KIRKLEES METROPOLITAN COUNCIL INVESTMENT & REGENERATION SERVICE

DELEGATED DECISION FOR DISCHARGE OF CONDITION A.4 - NOTIFICATION OF A PROPOSED ENLARGEMENT TO DWELLINGHOUSE

Reference no.	2024/HH/91407/E
Site Address	11, Northfield Avenue, Lockwood, Huddersfield, HD1 3SH
Description	The proposal is for erection of single storey rear extension. The extension projects 6m beyond the rear wall of the original dwellinghouse. The maximum height of the extension is 3.2m, the height of the eaves of the extension is 2.96m
Recommending Officer	Molly Storer

DECISION - REFUSED

Drawing 721-01
EXISTING & PROPOSED PLANS
& ELEVATIONS

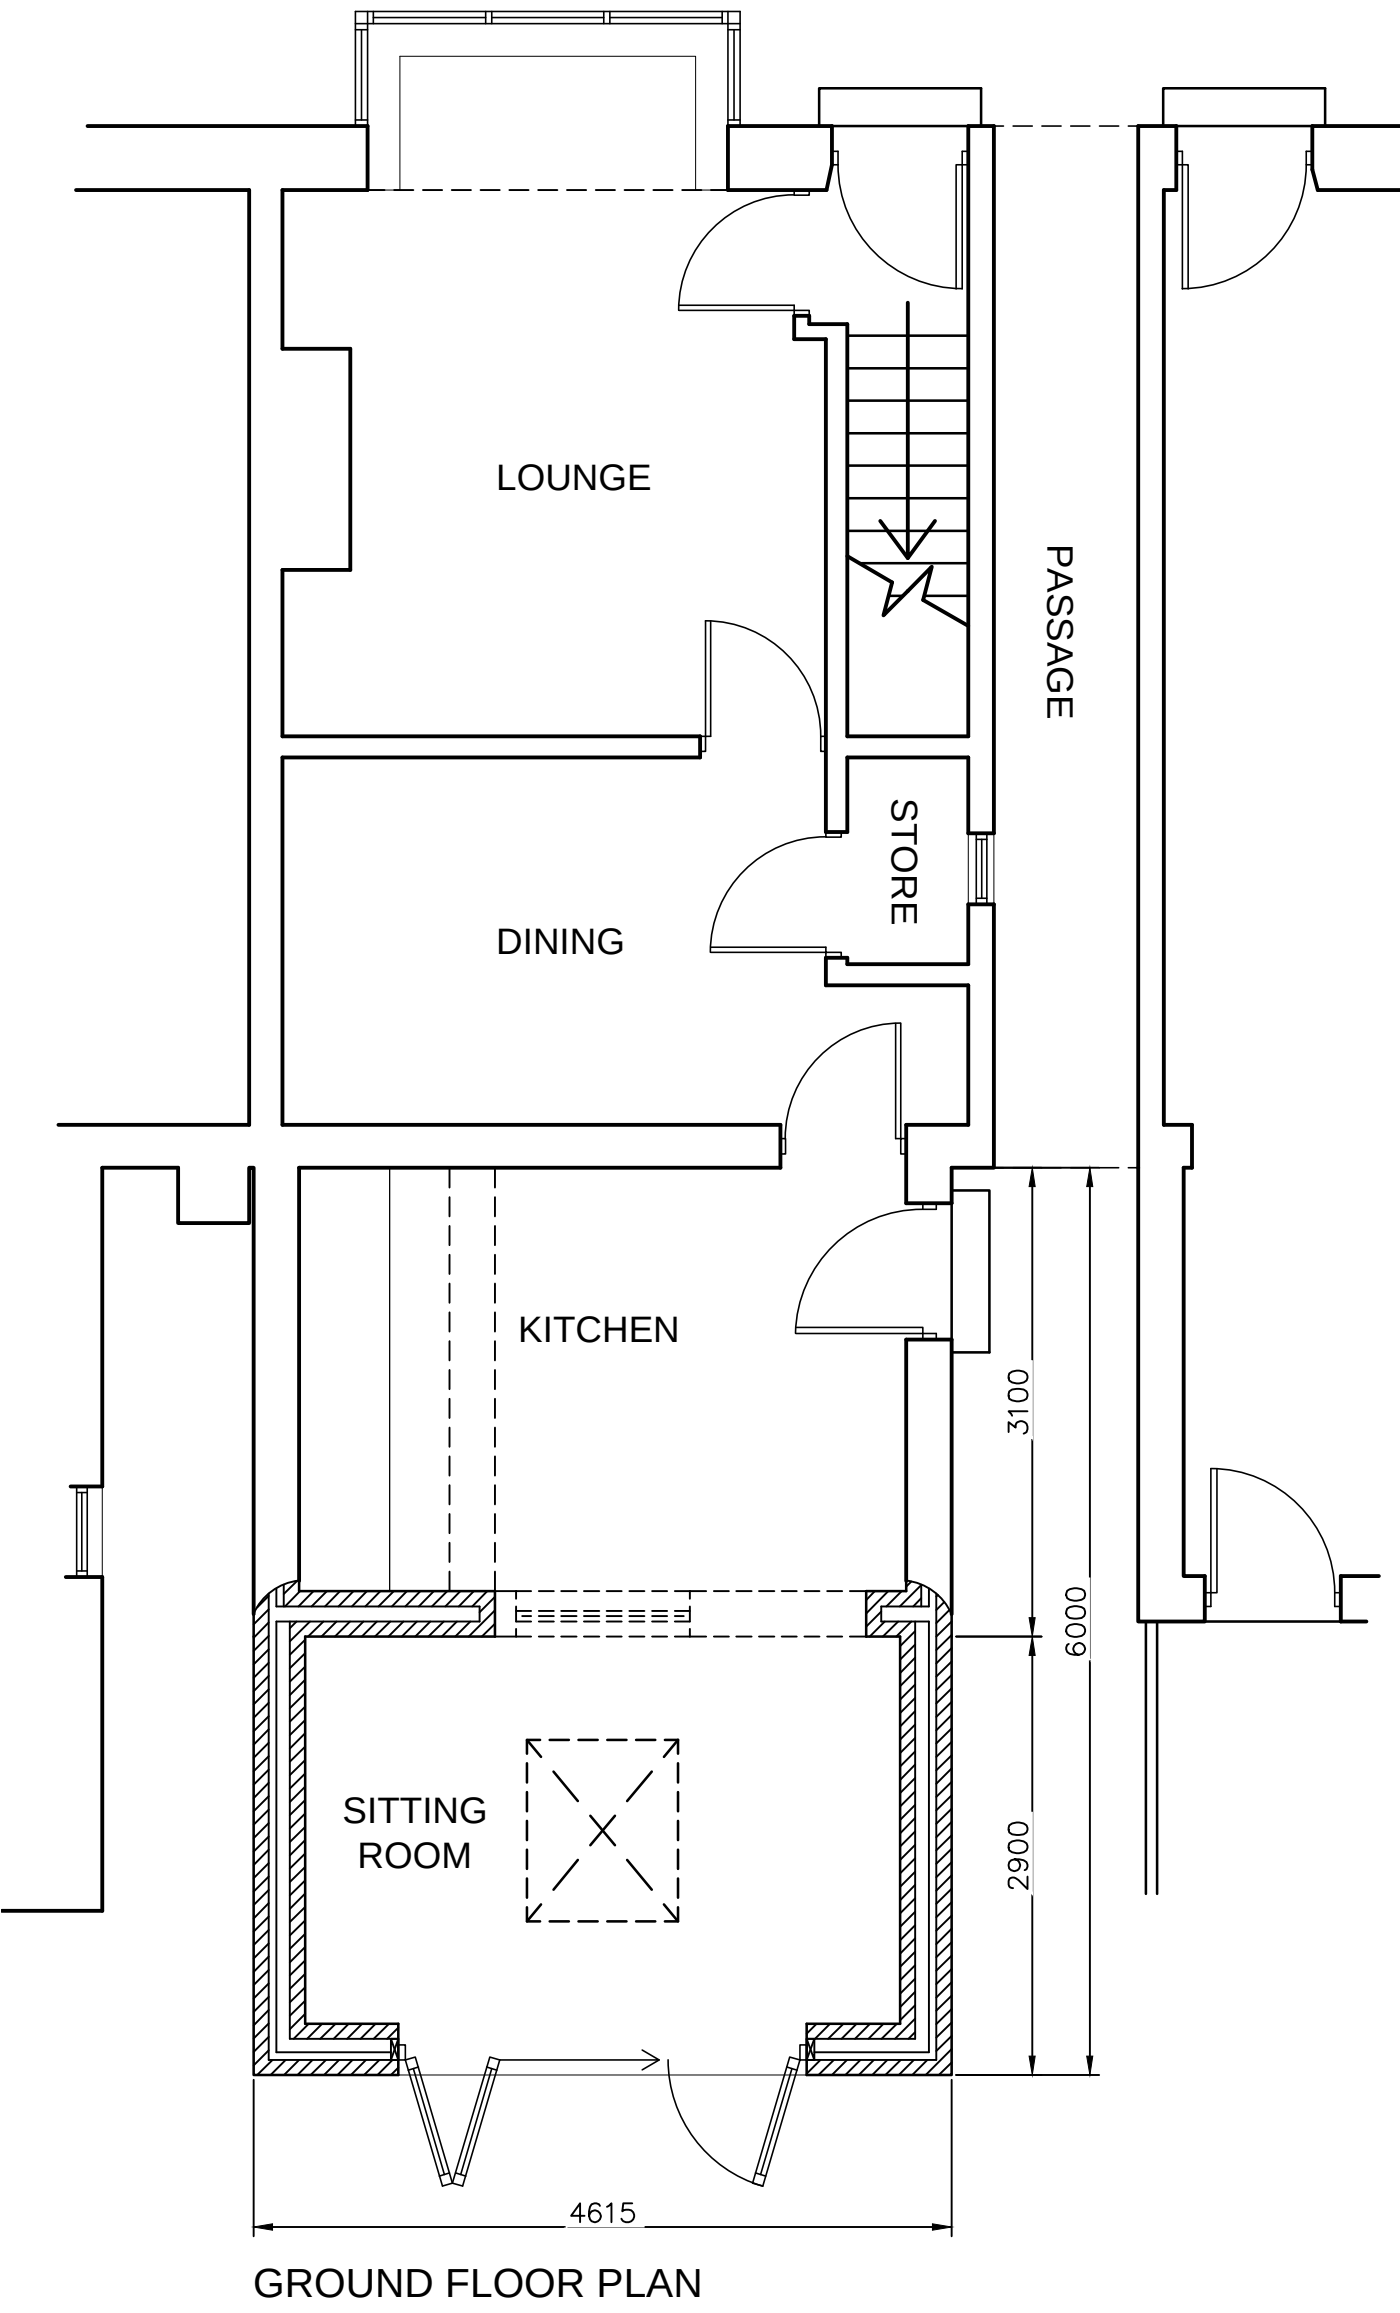
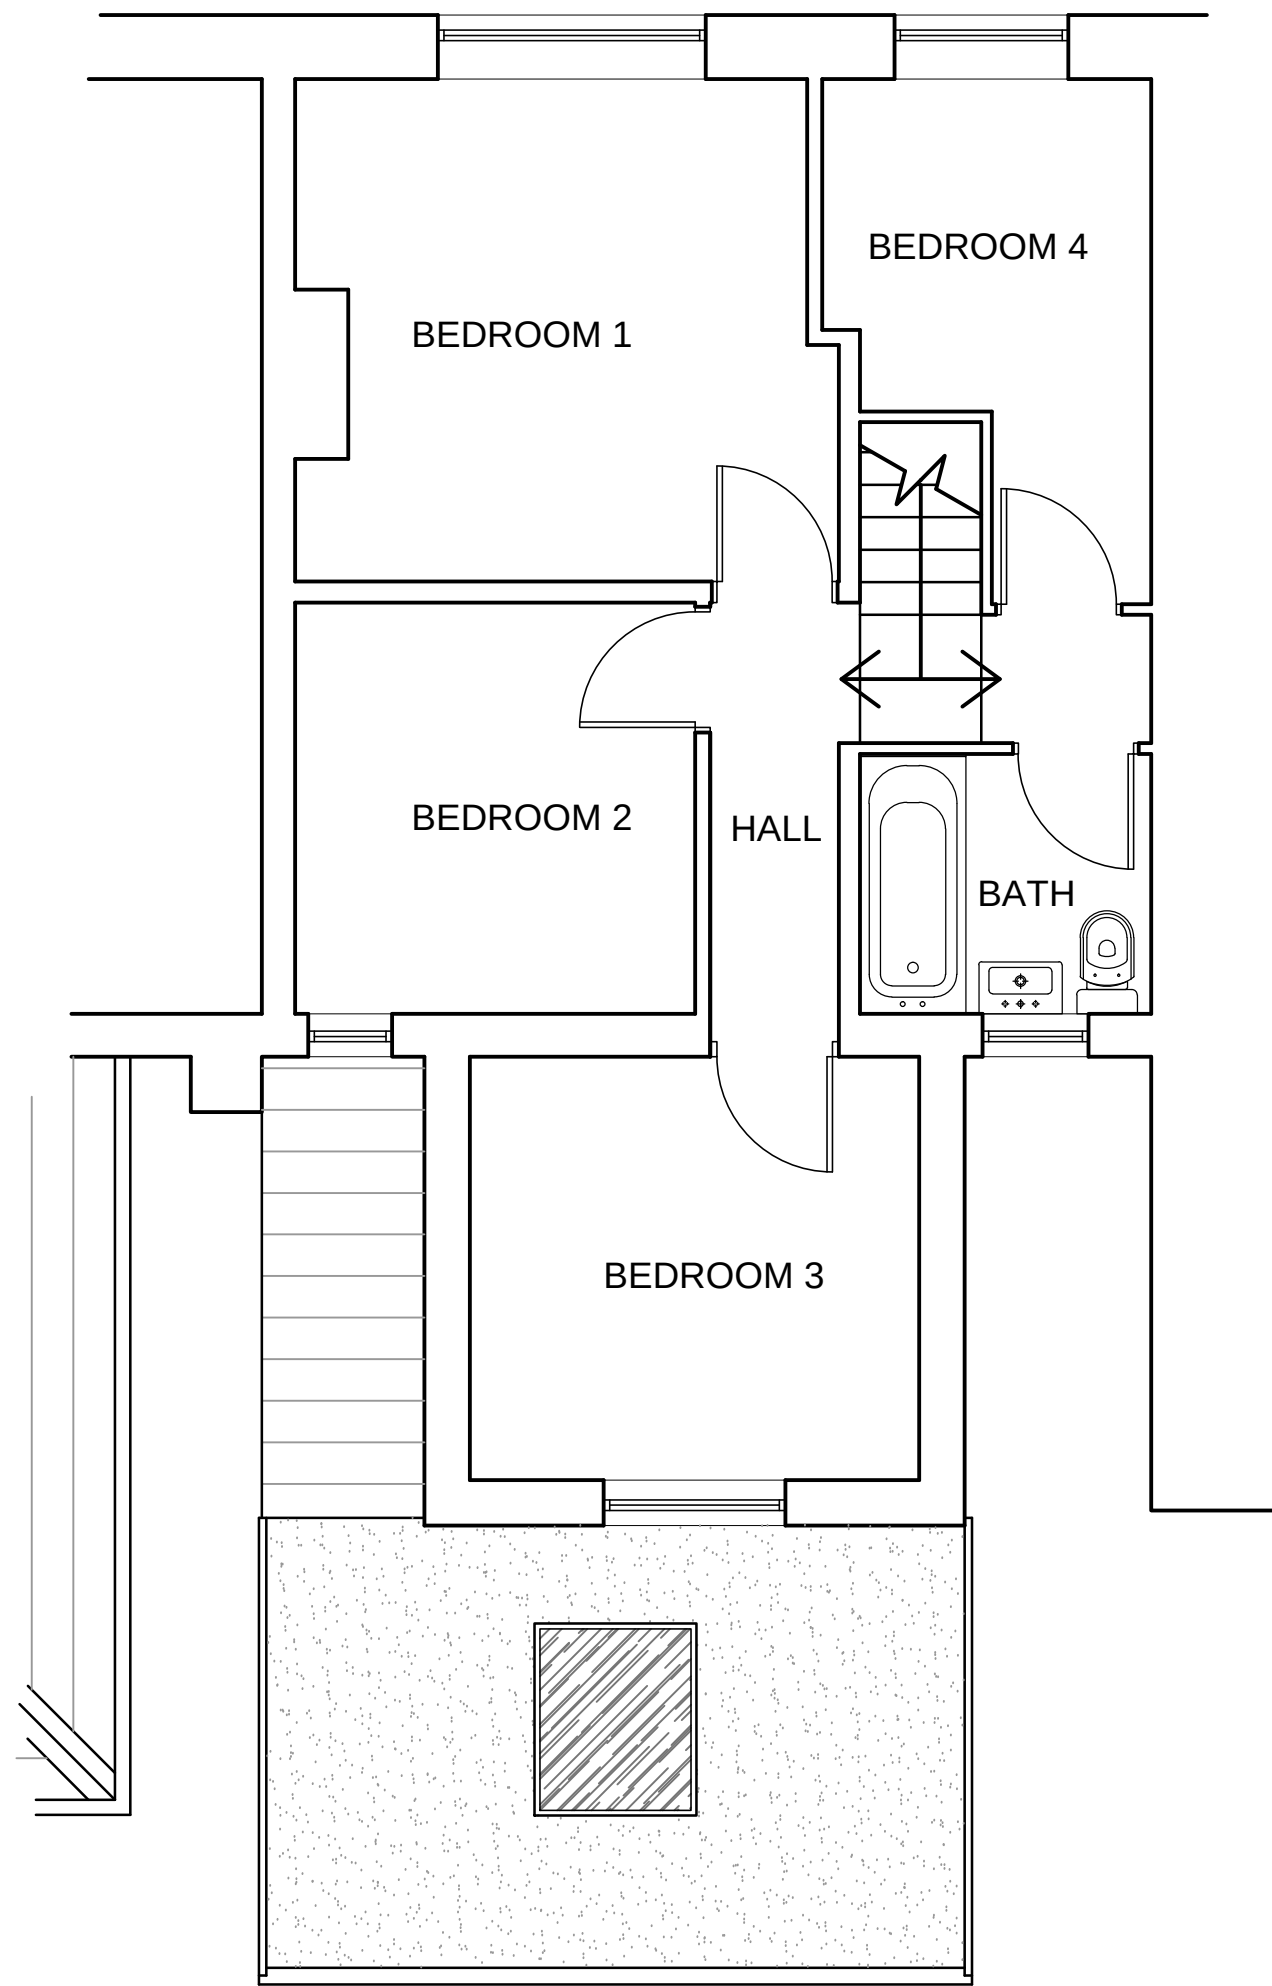
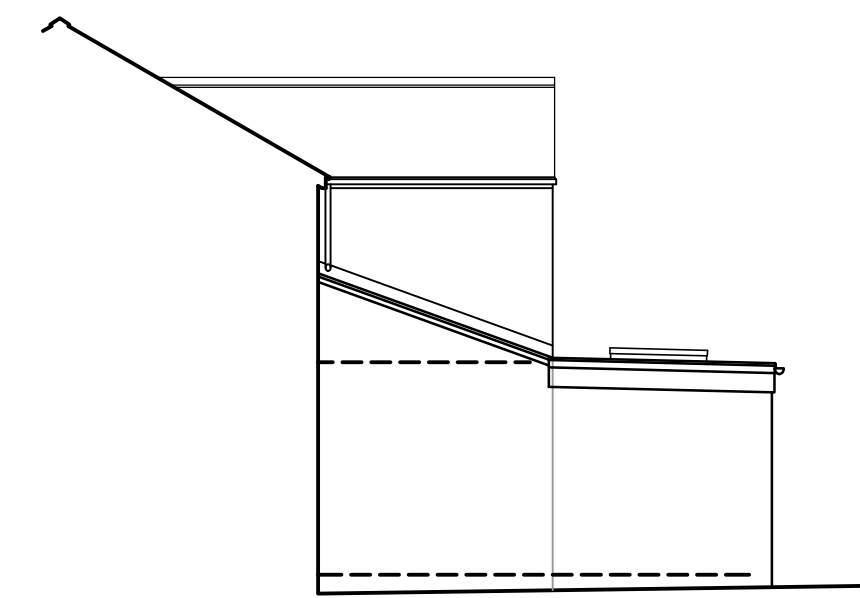
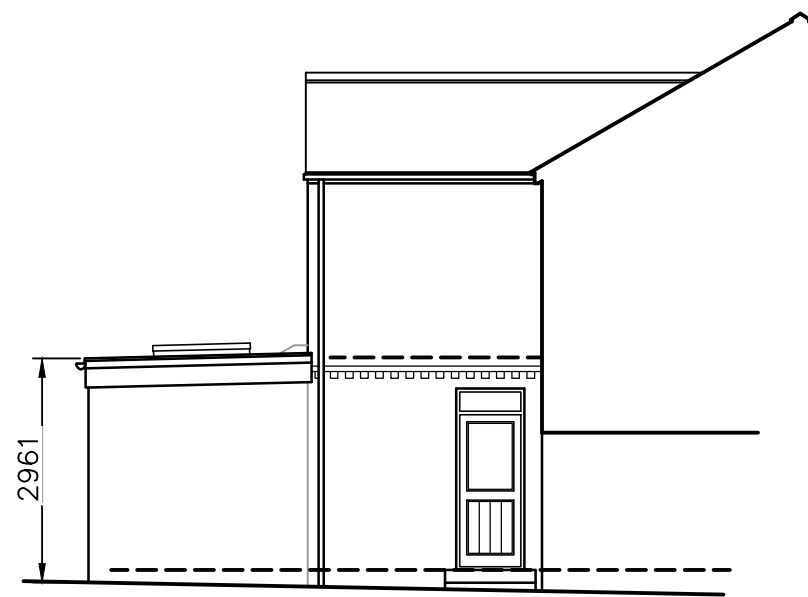
However, this condition does not impact the current proposal meaning that PD rights remain for this property for the erection of an extension. In addition, although there is previous development to the rear of the property, the additional extension will not result in an extension that projects more than 6m from the rear of the original dwellinghouse therefore is deemed acceptable.

However, sub- paragraph (ja) of Class A, Part 1, Schedule 2 of the Town and Country Planning (General Permitted Development)(England) Order 2015(as amended) provides that where proposed enlargements adjoin an existing enlargement to the original dwellinghouse then both the existing and proposed enlargement are to be considered as one enlargement for the purposes of assessing sub-paragraphs (e) to (j). In this instance, the combined two and single storey enlargements would have more than one storey and project 6 metres from the rear of the dwellinghouse and be within 2 metres of the boundary with an eaves height in excess of 3 metres contrary to sub-paragraphs (h) & (i).
